BUILDING CODE OF AUSTRALIA COMPLIANCE ASSESSMENT REPORT FOR DA SUBMISSION

MIXED USE DEVELOPMENT COMPRISING OF 4 BUILDINGS

93-107 CECIL AVENUE AND 9-10 ROGER AVENUE, CASTLE HILL

REPORT NO. ► 13685 Rev. 01

Drawing Title
BUILDING C - LEVEL 20

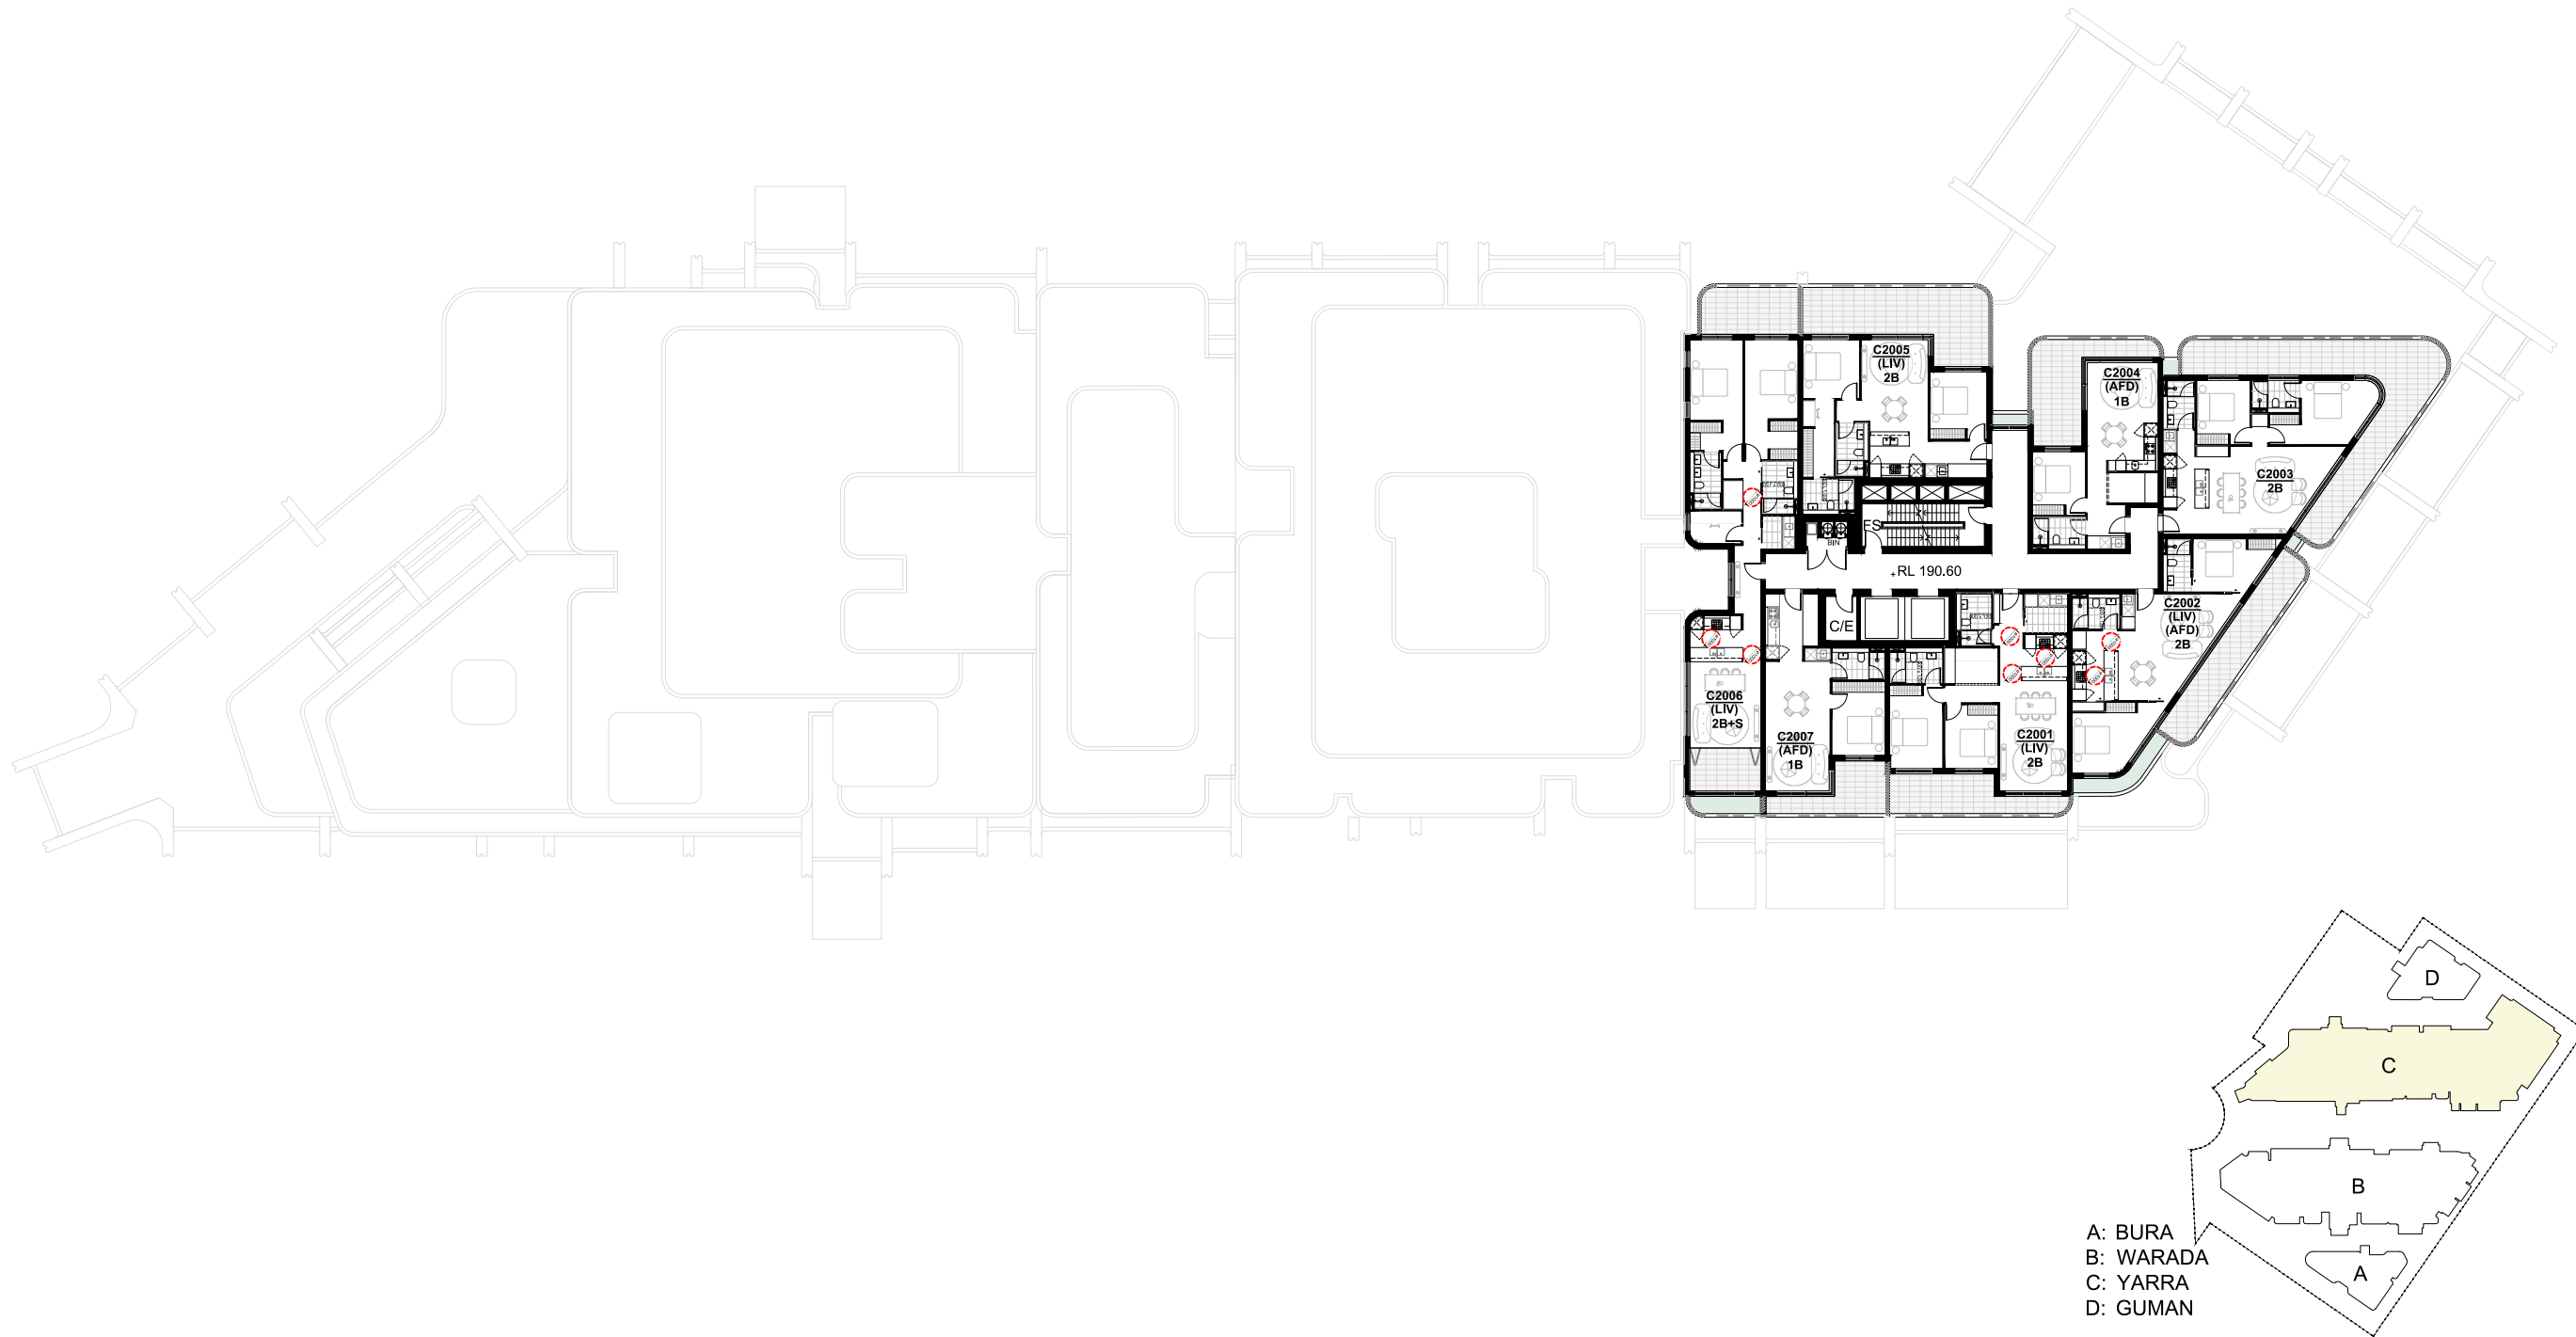
BCA Clause	Deemed-to-Satisfy Provision to be addressed
	<p>Level 20:</p> <ul style="list-style-type: none"> • <u>Building B (Northern fire stairways):</u> Distance between alternative exits is less than 9m (circa 7.7m). • <u>Building C (Northern fire stairways):</u> Distance between alternative exits is less than 9m (circa 7.7m). <p>Level 21-26:</p> <ul style="list-style-type: none"> • <u>Building C (Northern fire stairways):</u> Distance between alternative exits is less than 9m (circa 7.7m). <p>DTS Non-compliance:</p> <p>All scissor stairways are alternative paths of travel that converge such that they become less than 6m apart from each other. This will need to be addressed via a performance-based solution.</p>
<p>NSW D2D8</p> <p>Width of exits and paths of travel to exits</p> <p>[2019: D1.6(b), (c), (d) and (e)]</p>	<p>Further information required:</p> <p>Level 2: The commercial space to the northern side of building C has been assessed as a class 5 and has a floor area of approximately 304m². In accordance with D2D18, it can accommodate a maximum of 31 persons and therefore the aggregate width of exits must be no less than 1m. As there are no exit doorways detailed, it is unclear if the widths of the exit/s comply.</p>
